Subject: Re: FW: A/62/20/DOC - Pound Place, Roundstone Lane

I have the following comments regarding condition 3- surface water drainage:

DRAWING TITLE:
PROPOSED
IMPERMEABLE AREAS
SHEET 2

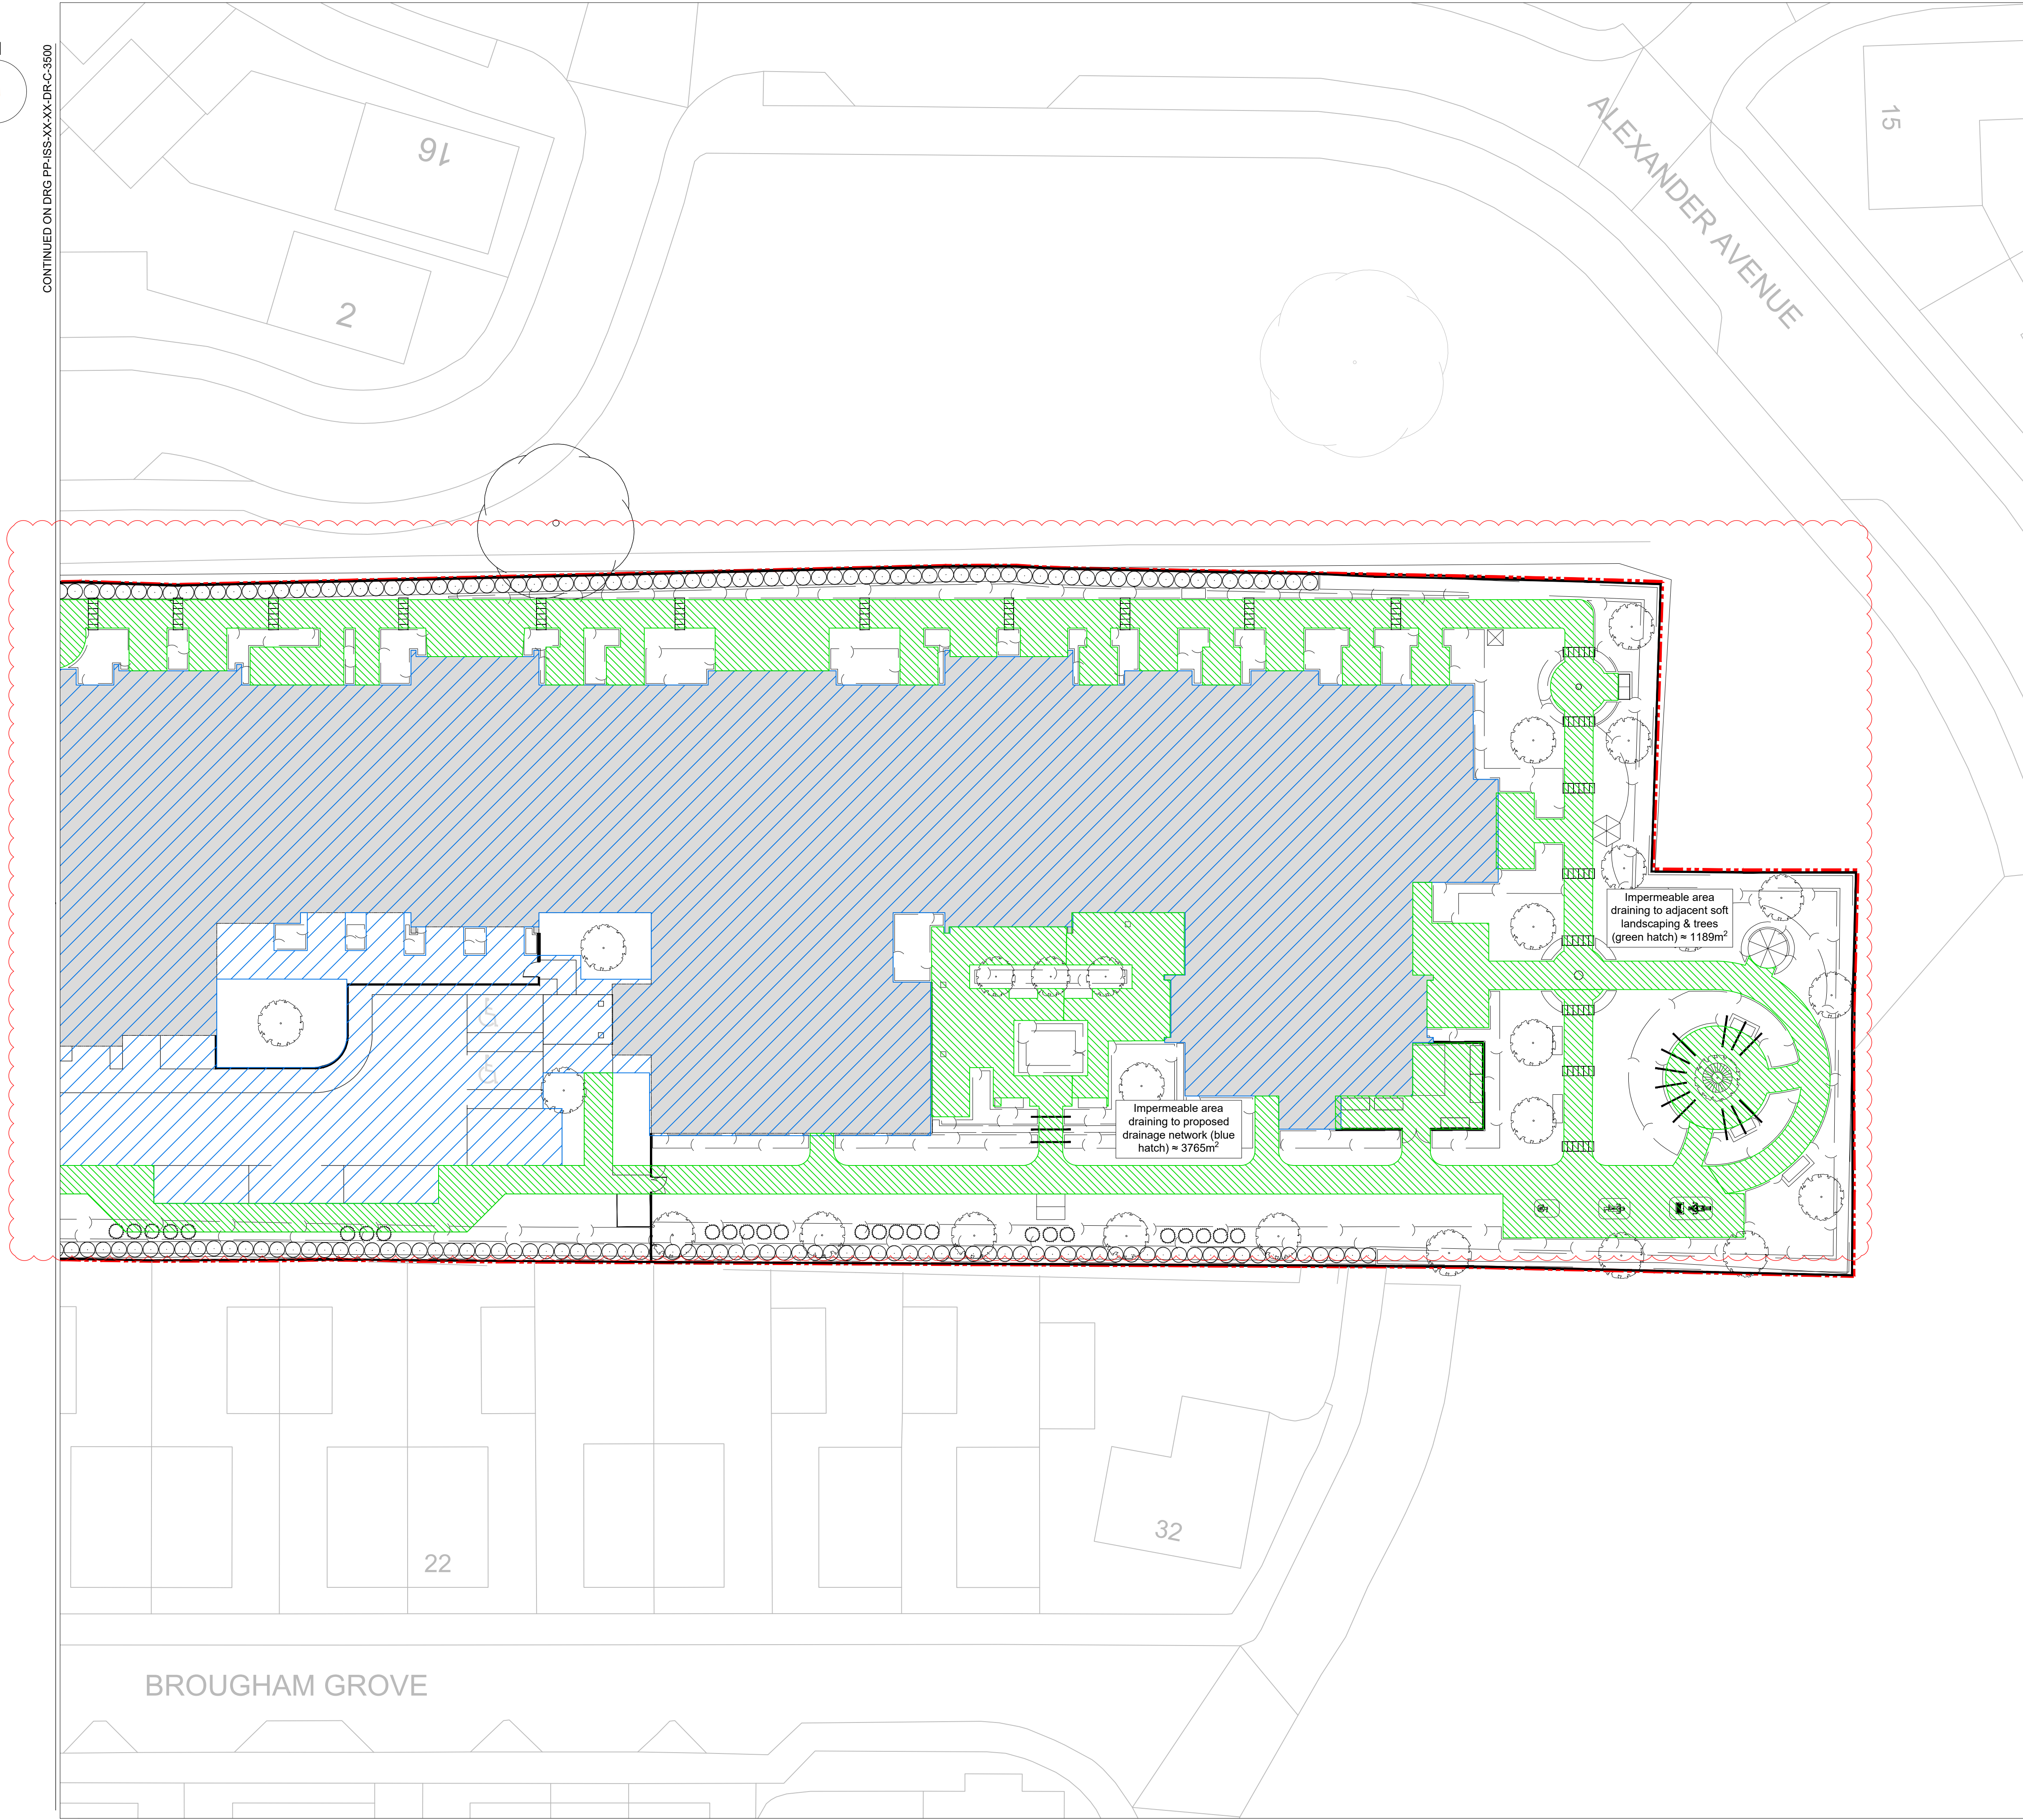
1. Please detail finish and formation levels of permeable paving on plans. I note that there are boxes that state "formation level approx. 0.5m from finished levels" but this is not accurate enough. Please provide spot levels as per drawings submitted for the previous approval.
2. Please provide a revised catchment area plan.
3. Porosity of soakaways in calculations is set to 1, please correct to 0.95 as per standard for crates.
4. Please provide invert levels of diffuser blocks on plan. Please detail diameter of pipes connecting from these to network on plan.
5. Please detail cover level of gullies.
6. The majority of cover levels and invert levels in SW network 1 are inconsistent between plans and calculations, please review and ensure consistency.
